Subject: 2025/92782 at location Land off, Litherop Lane, Clayton West, Huddersfield, HD8 9LT

Please see ecological commentary below:

SITE PLAN SCALE 1:200

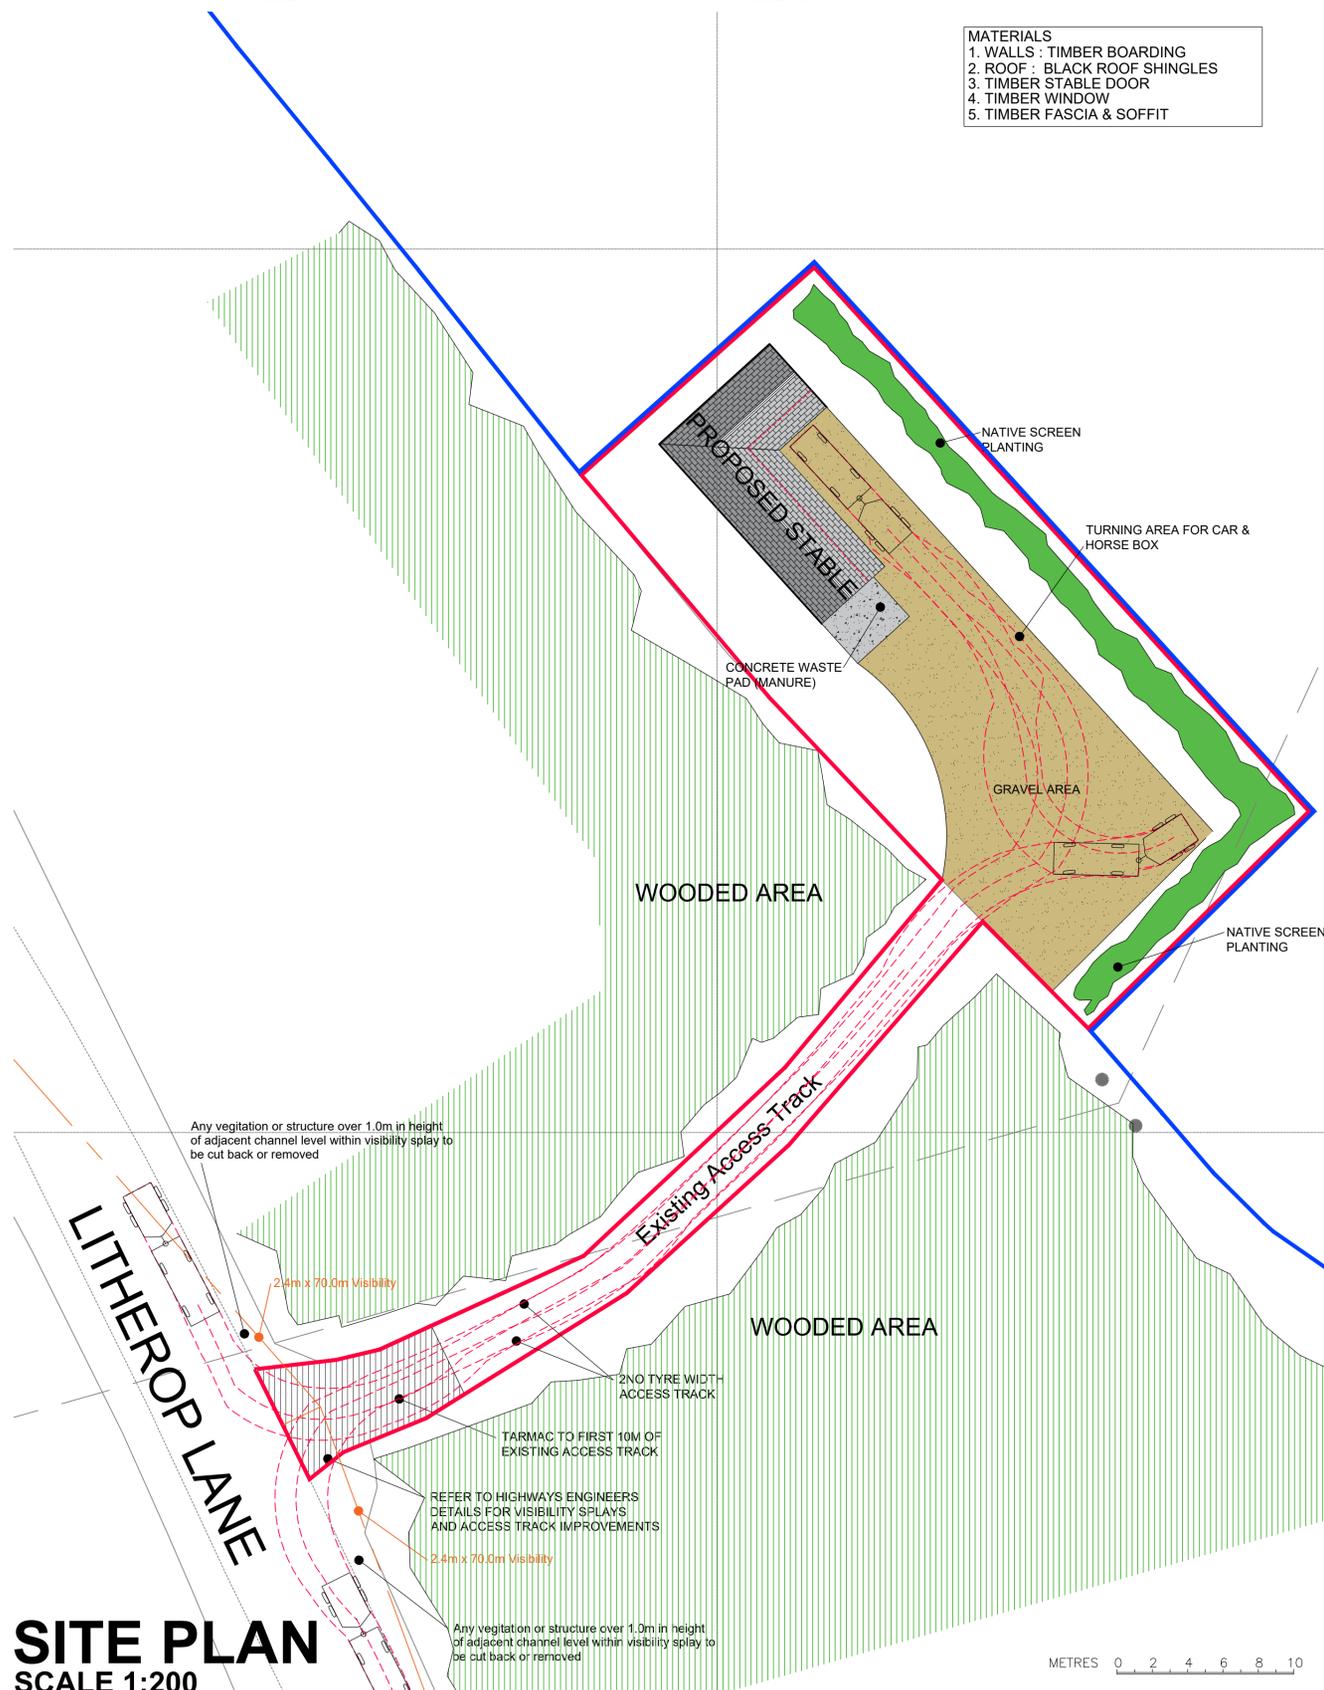
Works are taking place directly adjacent to trees and hedgerows, which will impact commuting species; as well as within 200m of Bentley Brook and River Dearne. As a result, a CEMP will be conditioned; along with tree/hedgerow protection and lighting strategy requirements. At this point in time I do not believe a PEA is warranted – however I do think the DLL (NatureSpace) should be consulted for GCN and the local Badger Group should also be consulted for data.

A Hedgerow and Tree Protection Plan detailing measures for the protection of trees and hedgerows during the works will be submitted to and approved by the LPA prior to the commencement of works on site, including site clearance and delivery of materials.
